From: Michael Eastham <Michael.Eastham@arun.gov.uk>
Sent: 11 April 2020 14:47
To: Planning.Responses <Planning.Responses@arun.gov.uk>
Subject: FW: BN/85/19/DOC - The Lillies

Please upload the email trail below from **ADC Drainage Engineers** onto Ocella for **BN/85/19/DOC – The Lillies**.

I have received the email below from the applicant for BN/85/19/DOC at the Lillies, Yapton Road in Barnham.

From: Paul Cann <Paul.Cann@arun.gov.uk>
Sent: 06 February 2020 15:41
To: Michael Eastham <Michael.Eastham@arun.gov.uk>
Cc: Sarah Burrow <Sarah.Burrow@arun.gov.uk>
Subject: RE: BN/85/19/DOC - The Lillies

SFA10C Headwall
SFA1 450 Outfall Safety Grille
3 Sided Kee Klamp

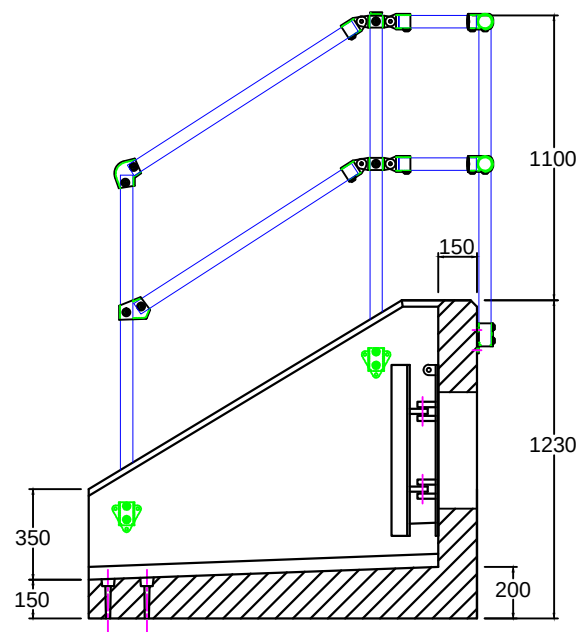
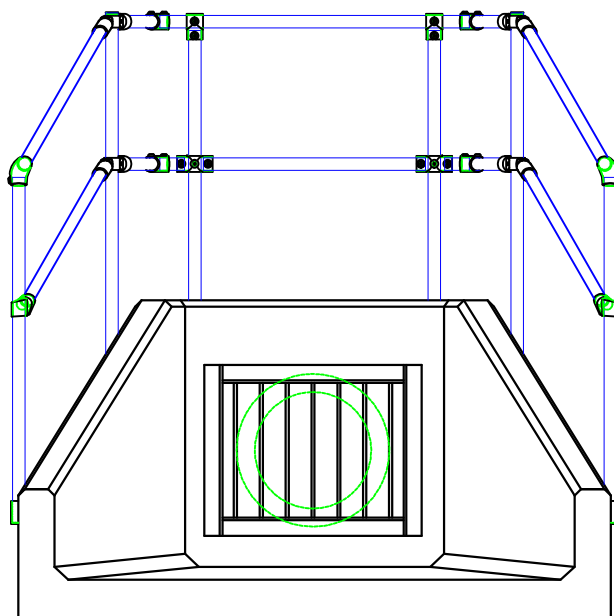
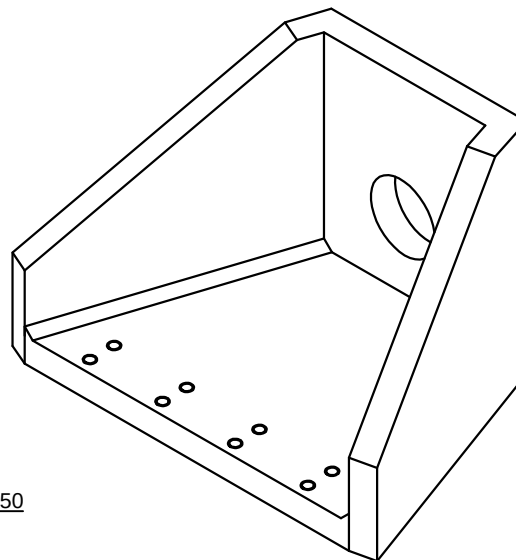
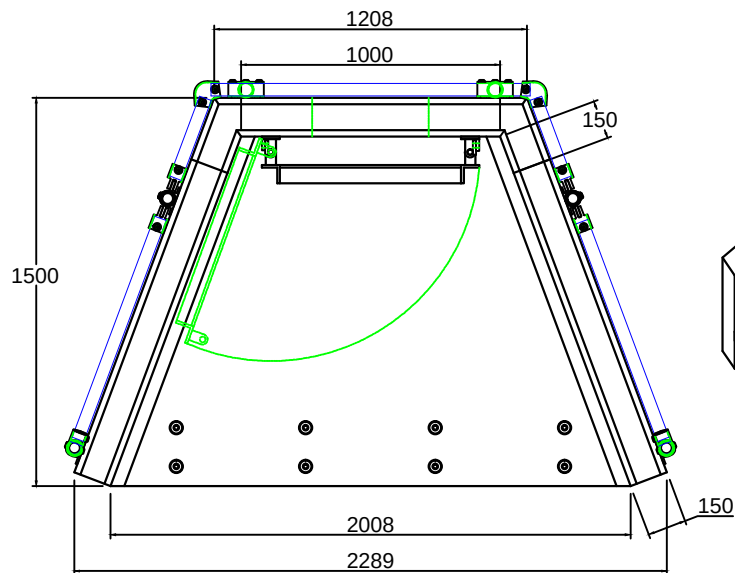
27. Headwall SFA10A incorrectly specified for the pond headwall – this should be SFA10C and SFA10A specified for the discharge to the ditch. This is not within the remit of the LLFA. This is a s104 matter it also considered part of the remit of the LPA.

DETAILS PRIVATE CONSTRUCTION DETAILS

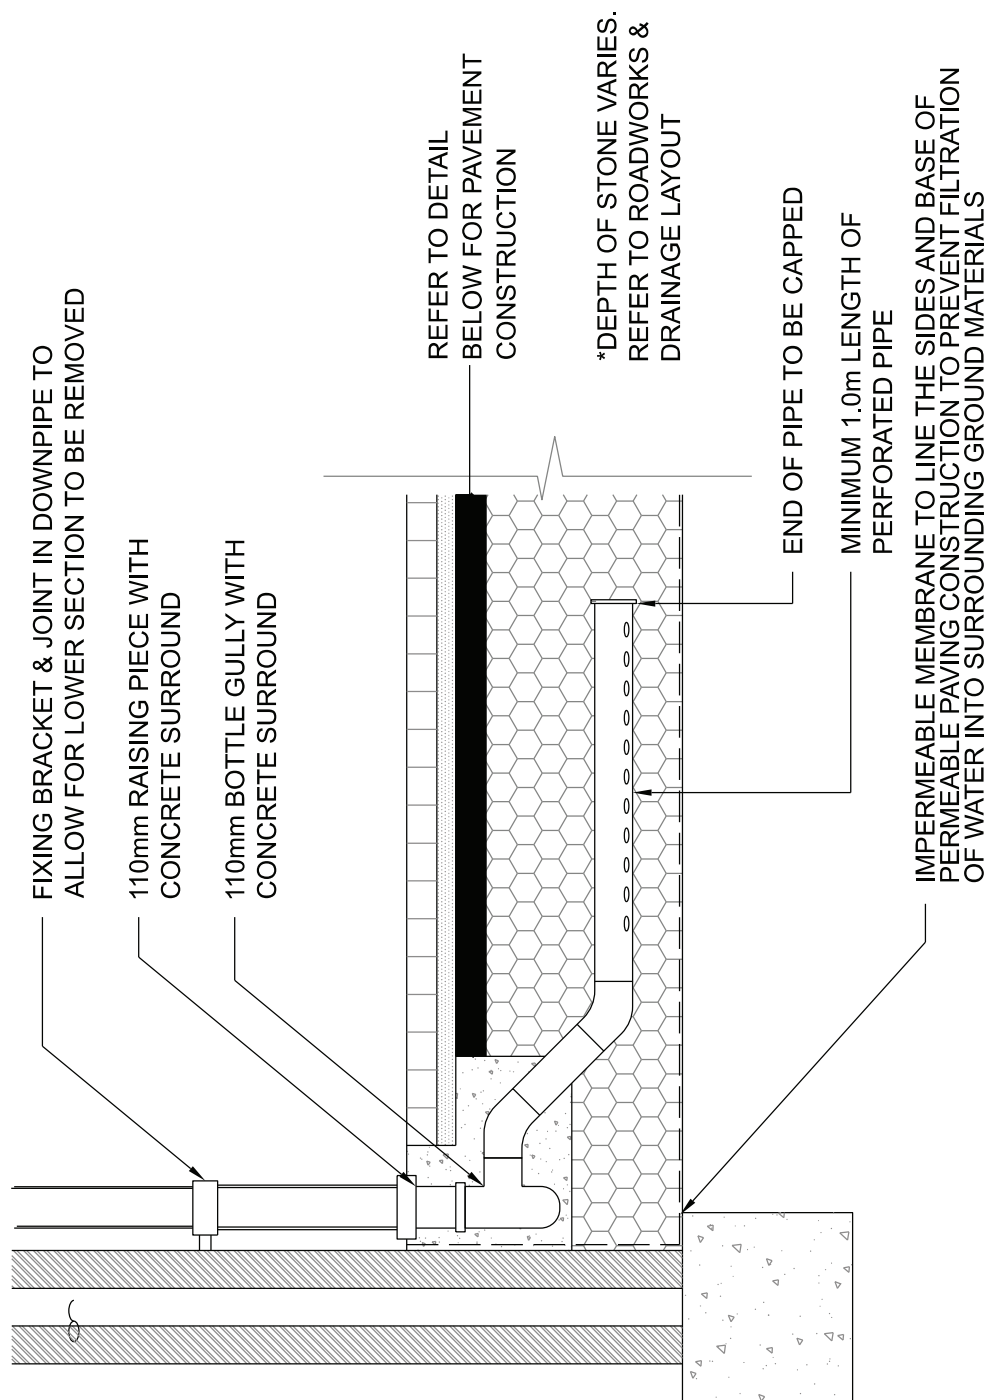
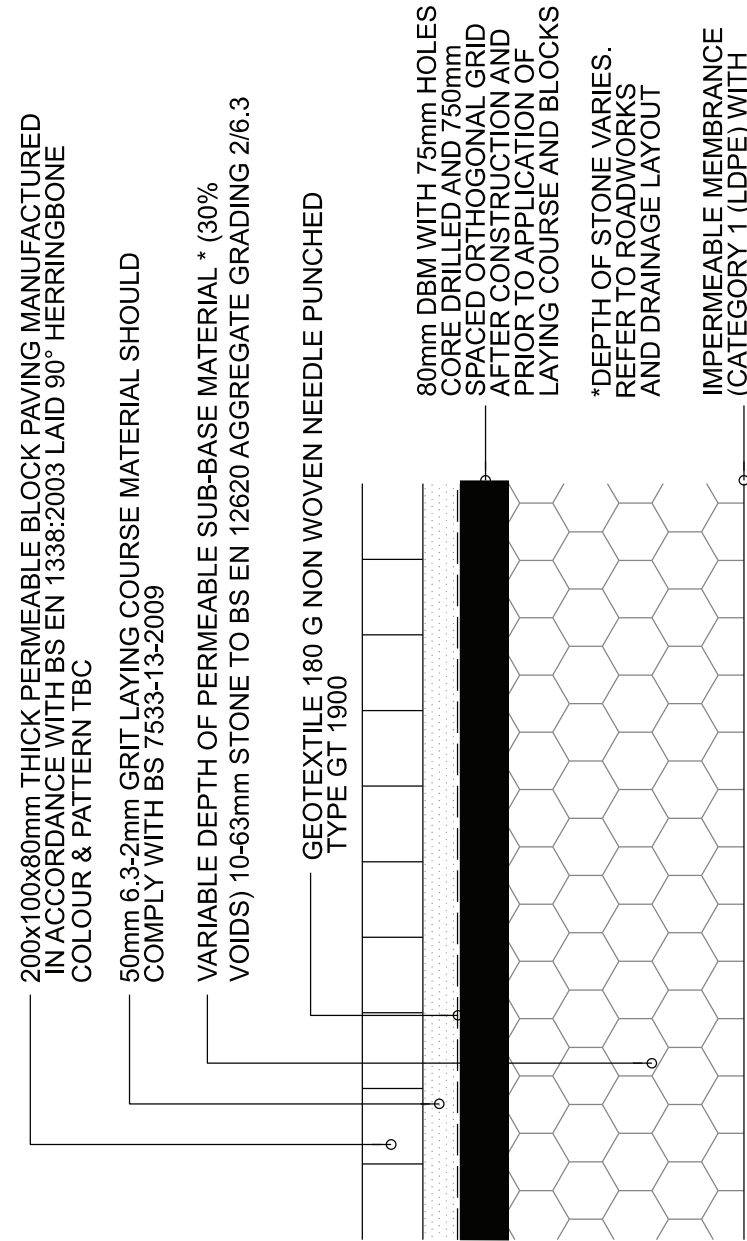
6. All discharges into permeable pavement structures will need to be connected via a diffuser unit and a catchpit manhole incorporated upstream of each unit. Any bends to incorporate a manhole. Construction

details to be provided for the diffuser units and catchpit manholes. Specify pipe invert levels at the diffuser unit and the manholes. Specify pipe diameters on all connections. I don't believe it is within the remit of the LLFA to dictate site level details. Our proposed details are shown on our private construction details.

11. Make sure all RWP's are shown clearly ie. thicken lines. This is not within the remit of the LLFA. Disagree
12. Where the existing public foul sewer gravity sewer and rising main passes beneath the permeable pavements, are you proposing the service corridor construction arrangement – If so, detail how water can flow between the separate sub bases. No. These features pass beneath the permeable paving construction. Yes the sewer below is appreciated but is the backfill above the sewer permeable construction? Provide a detail.

DETAILS	TYPICAL HEADWALL DETAILS
---------	--------------------------

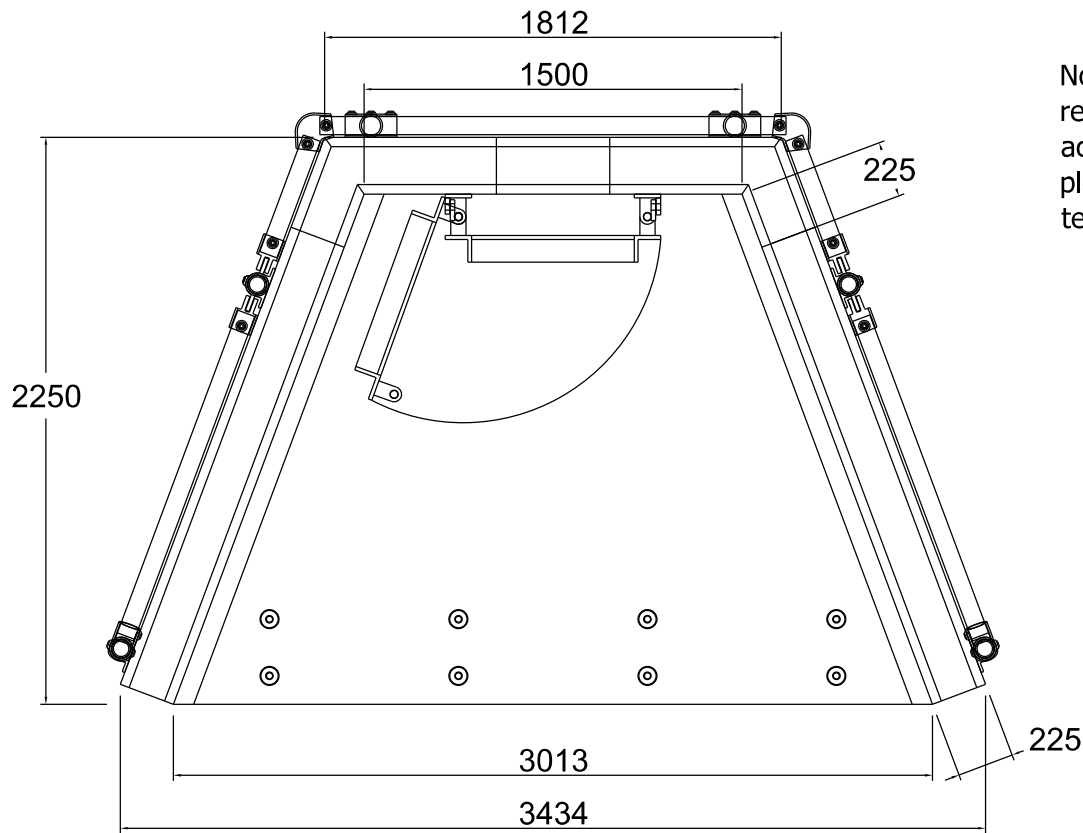
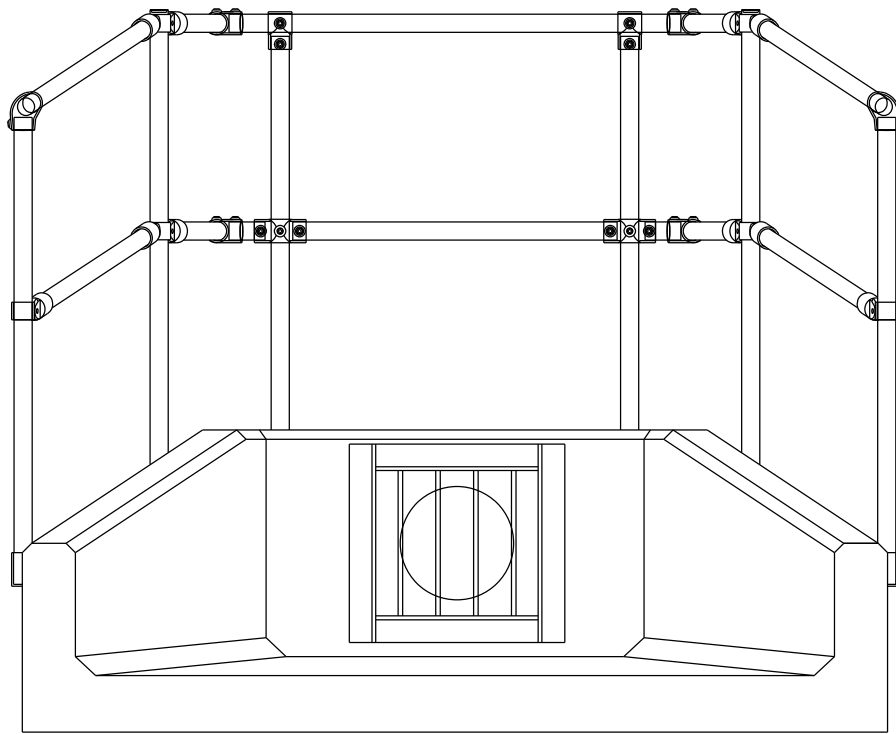
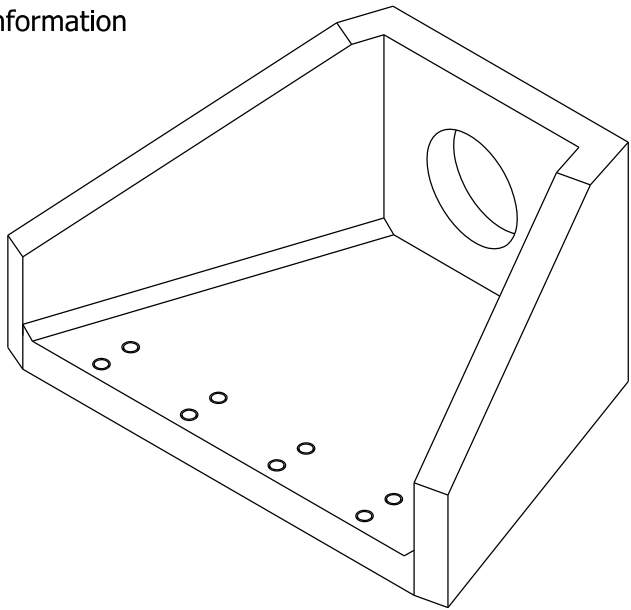
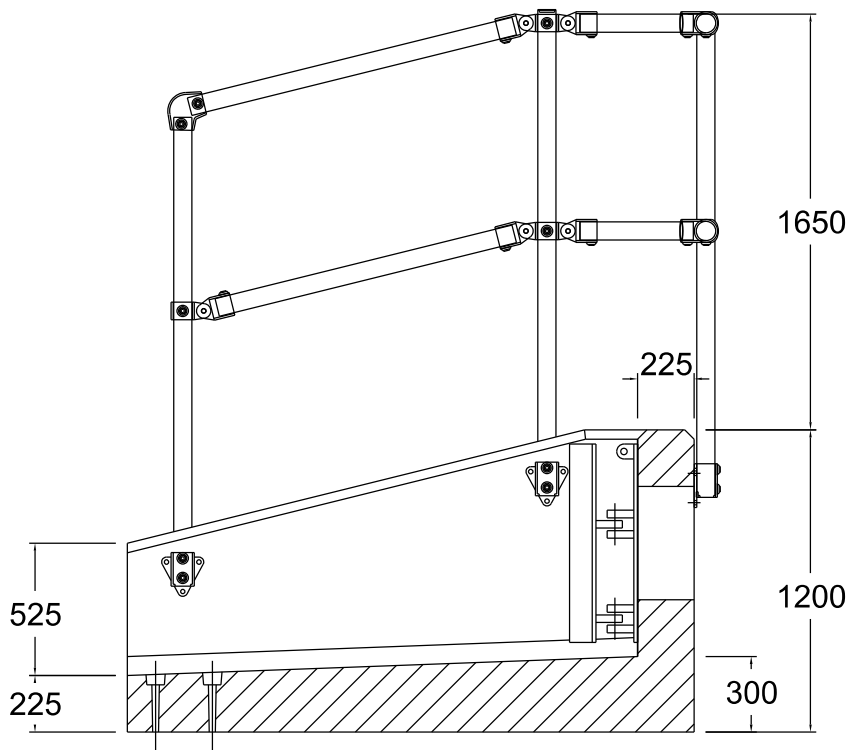
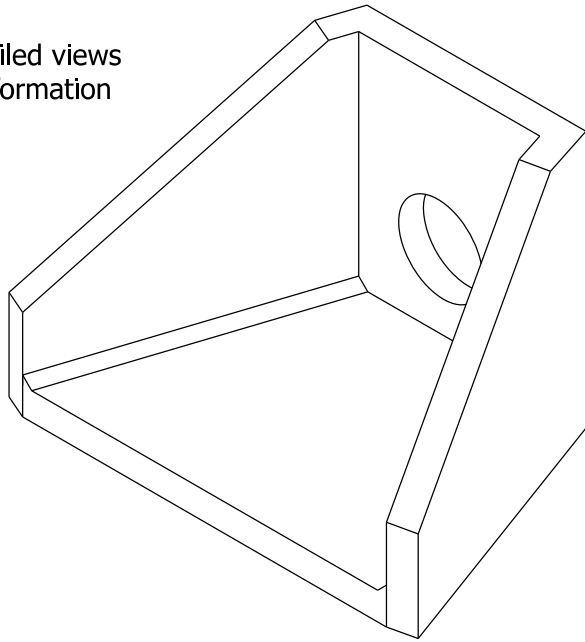
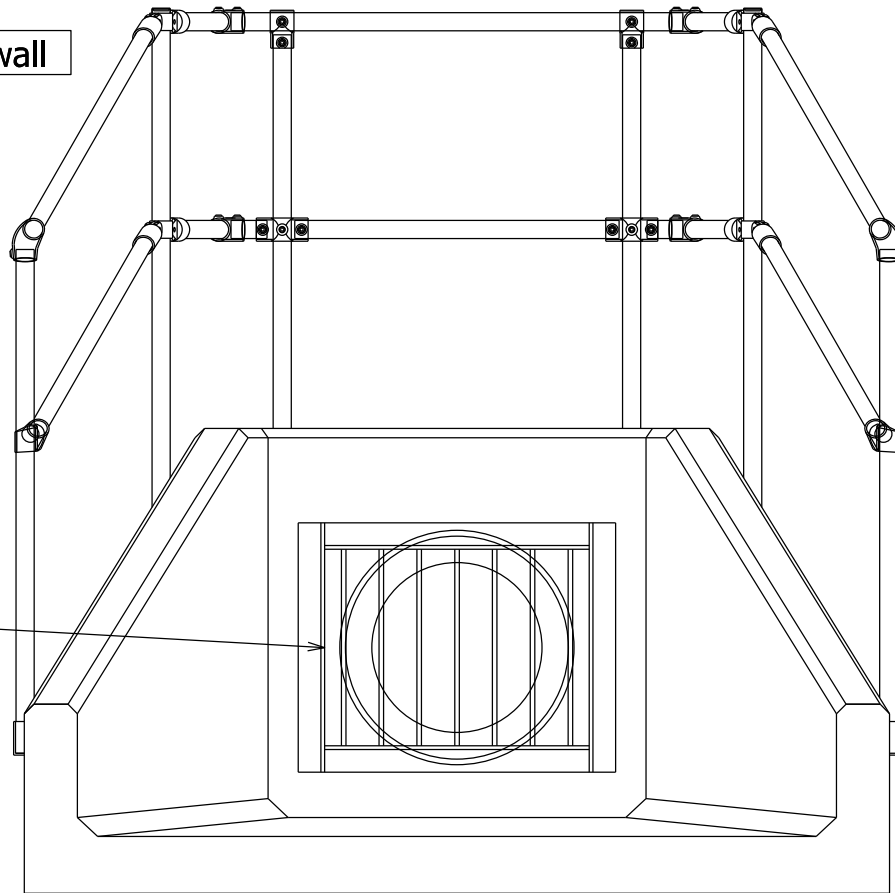
28. Pond headwall – specify a 'cranked' grille to suite a 450mm pipe. Banks in vicinity of headwall to be profiled to suit wing walls – add note. This is not within the remit of the LLFA. This is a s104 matter It also considered part of the remit of the LPA.

31. Headwalls – add note 'To be bedded as per manufacturers recommendations'. This is not within the remit of the LLFA. This is a s104 matter It also considered part of the remit of the LPA.
